5 May 2023

Refer: 7425-5.1L

SHOALHAVEN STARCHES – MOD 9 & 21 – PACKING PLANT DESIGN NOISE VERIFICATION

Day Design Pty Ltd has been engaged to prepare a Design Noise Verification Report for modification approval MP 06_0228 issued by the Minister for Planning for the Packing Plant and container storage yard to be constructed at Lot DP 1121337 and Lot 2 DP 538289 Bolong Road, Bombaderry, NSW (Modification 9) and Packing Plant Alterations and Other Works (Modification 21).

Noise Barrier Walls

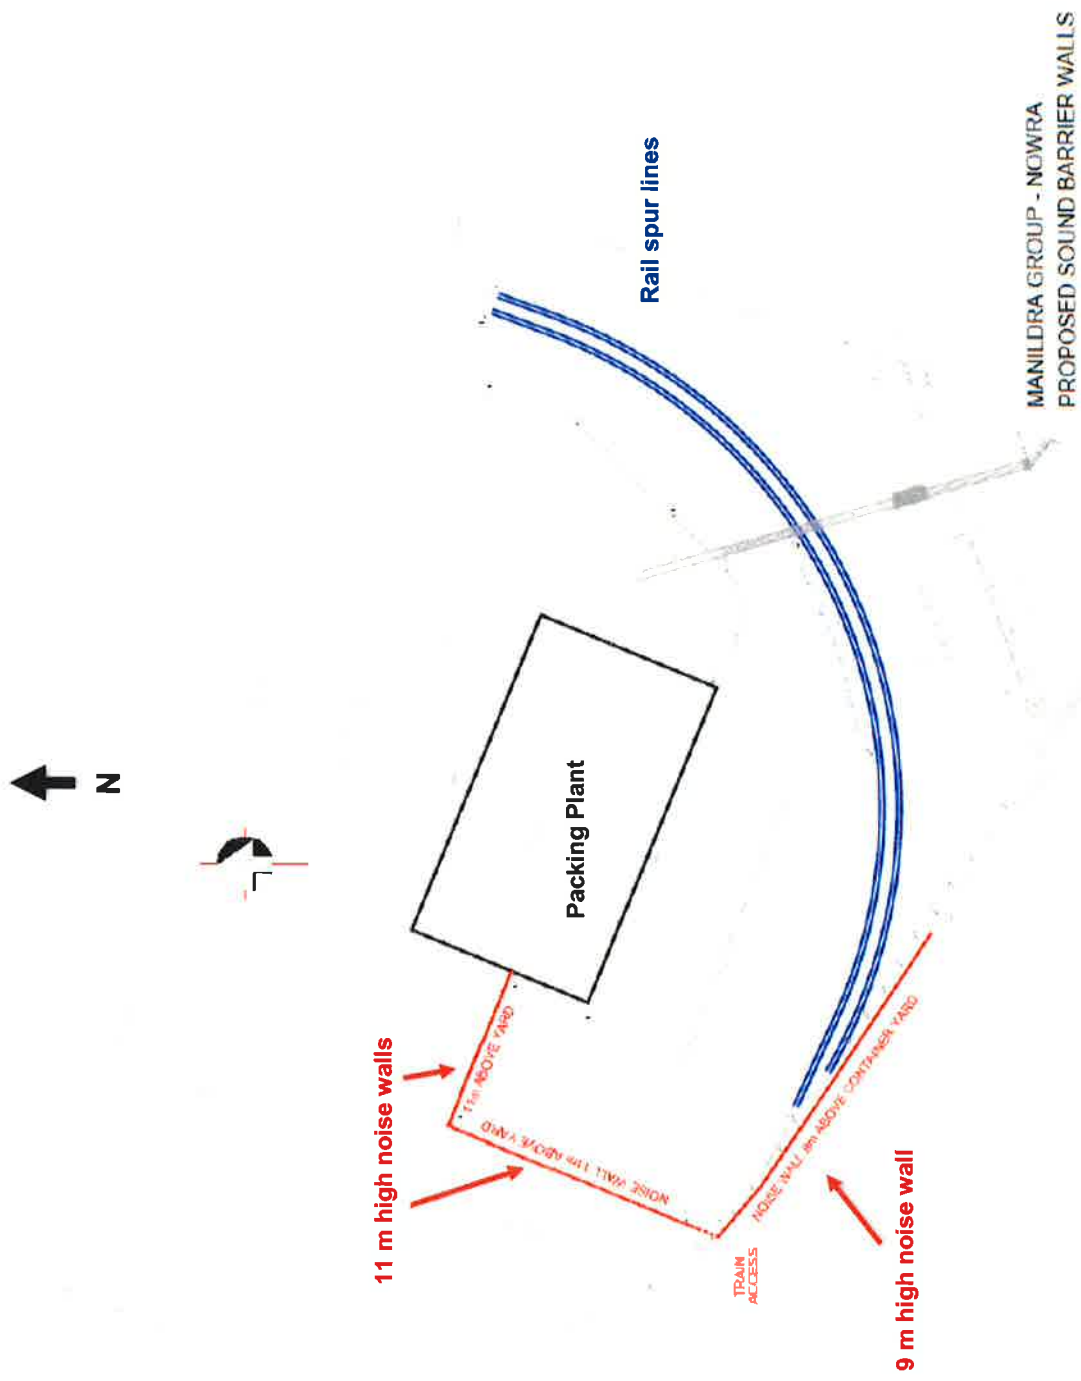
We have reviewed the 'For Construction' drawings of the proposed noise wall, as prepared by ROC Engineering & Design dated 12 July 2022. The height of the noise wall sections along the northwest and northeast boundaries of the container storage area varies in height from 11.05 metres (Post № 37) to 13.78 metres (Post № 16) above ground level of the container storage yard. Therefore, the requirements specified in item e) are satisfied.

We have reviewed the 'For Construction' drawings of the proposed noise wall, as prepared by ROC Engineering & Design dated 12 July 2022. The height of the noise wall sections along the southwest boundary of the container storage area varies in height from 10.43 metres (Post № 69) to 9.32 metres (Post № 42) above ground level of the container storage yard. Therefore, the requirements specified in item f) are satisfied.

We have reviewed the 'For Construction' drawings of the proposed noise wall, as prepared by ROC Engineering & Design dated 12 July 2022. The noise wall is found to be contiguous in construction with no gaps between sections. All gaps between the base of the wall and tops of footings are found to be in general accordance with the requirements of item g).

However, it can be seen from the drawings that a number of sections have gaps between the base of the wall panel and ground level which are larger than 50 mm. These gaps shall be filled with earth or construction aggregate to prevent noise leakage underneath the noise wall.

Location of Building Openings

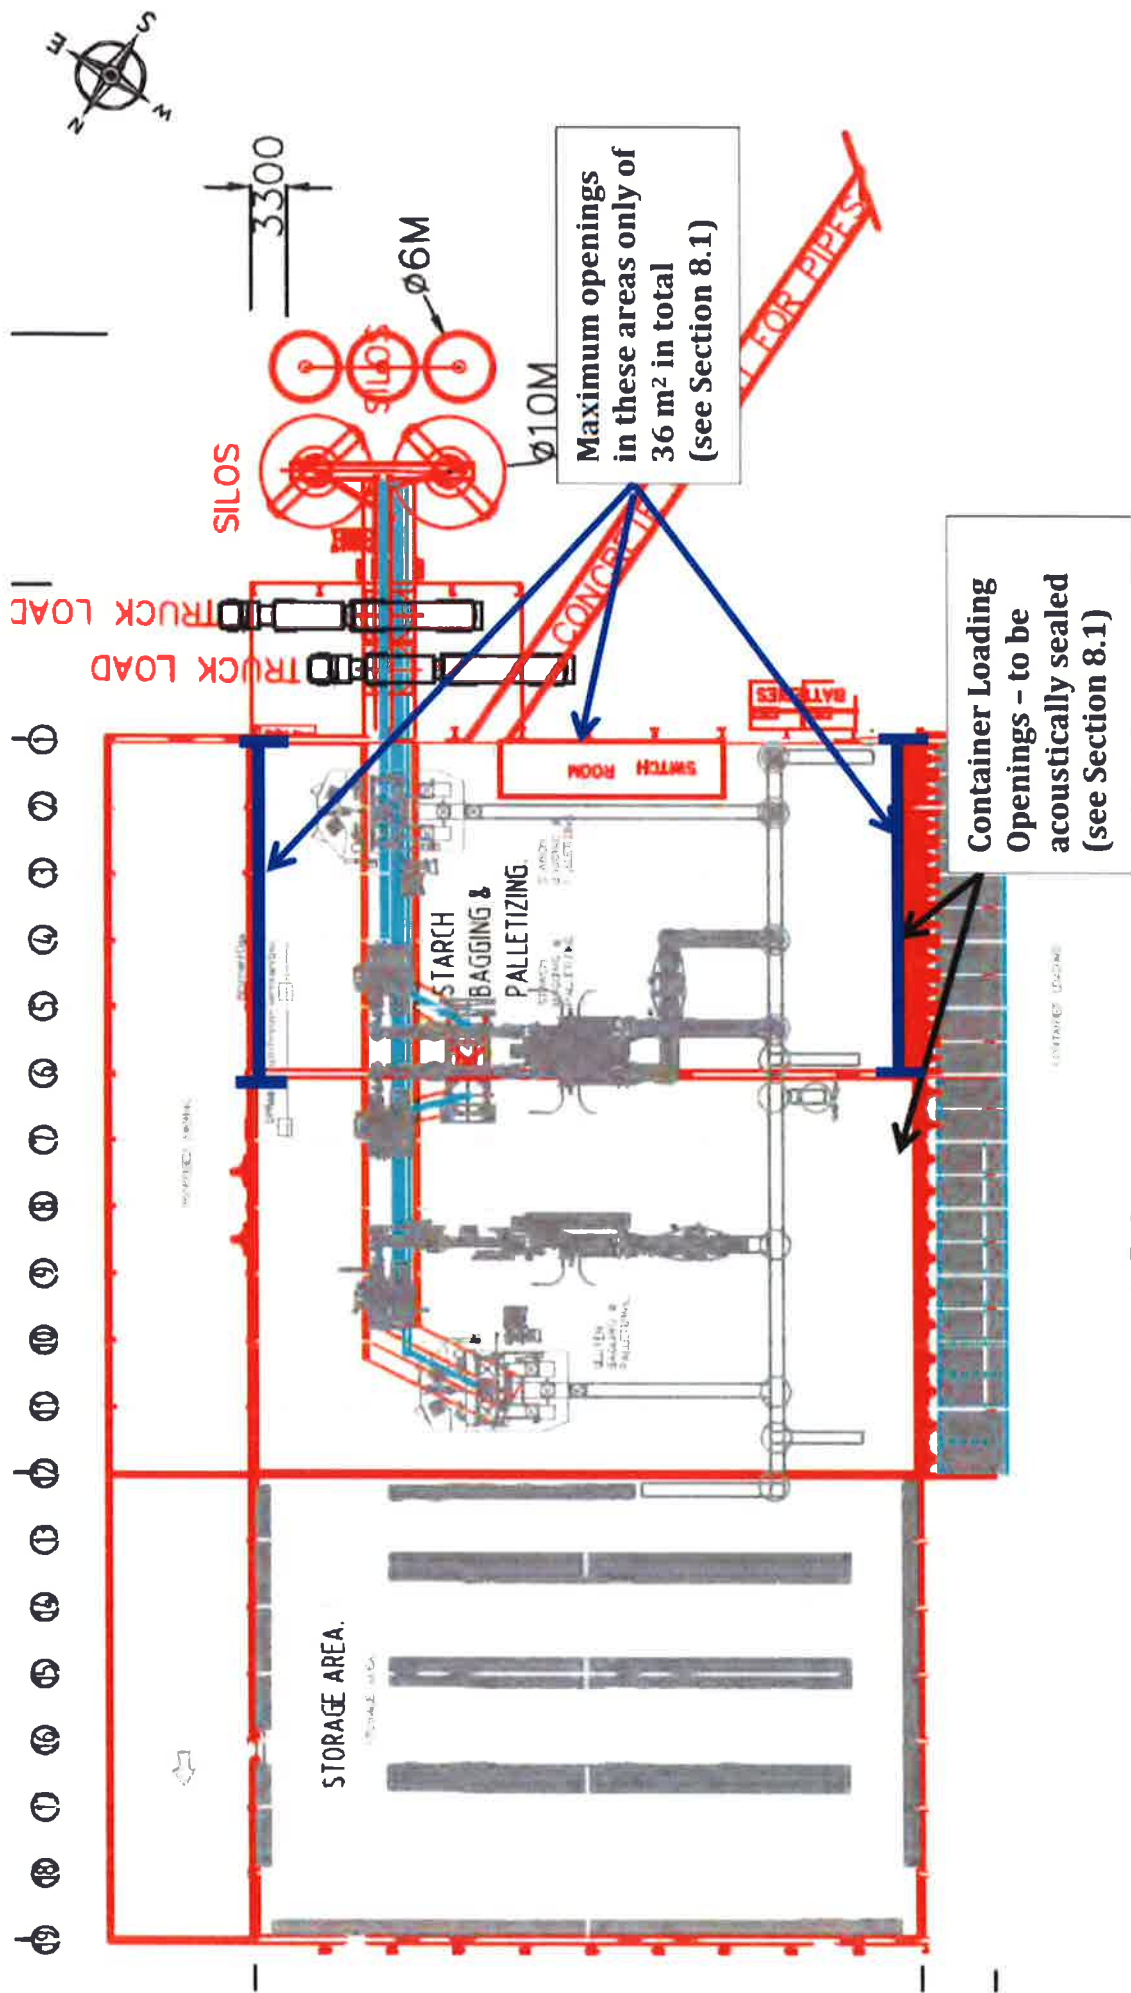
The current design of the penthouse level specifies four wall openings on the northeast facades of Level 2 and Level 4.5 and are not acoustically treated. Each opening is approximately 2m² for a total untreated area of approximately 16 m². Noise modelling of the north packing plant facility indicates that these acoustically untreated openings do not compromise the overall integrity of the external walls and compliance with the design noise goals will be met. There are no other untreated openings within the packing plant building or penthouse level.

This design acoustically satisfies the intent of this condition with respect to acoustically treated openings whilst maintaining the acoustical integrity of the building façade.
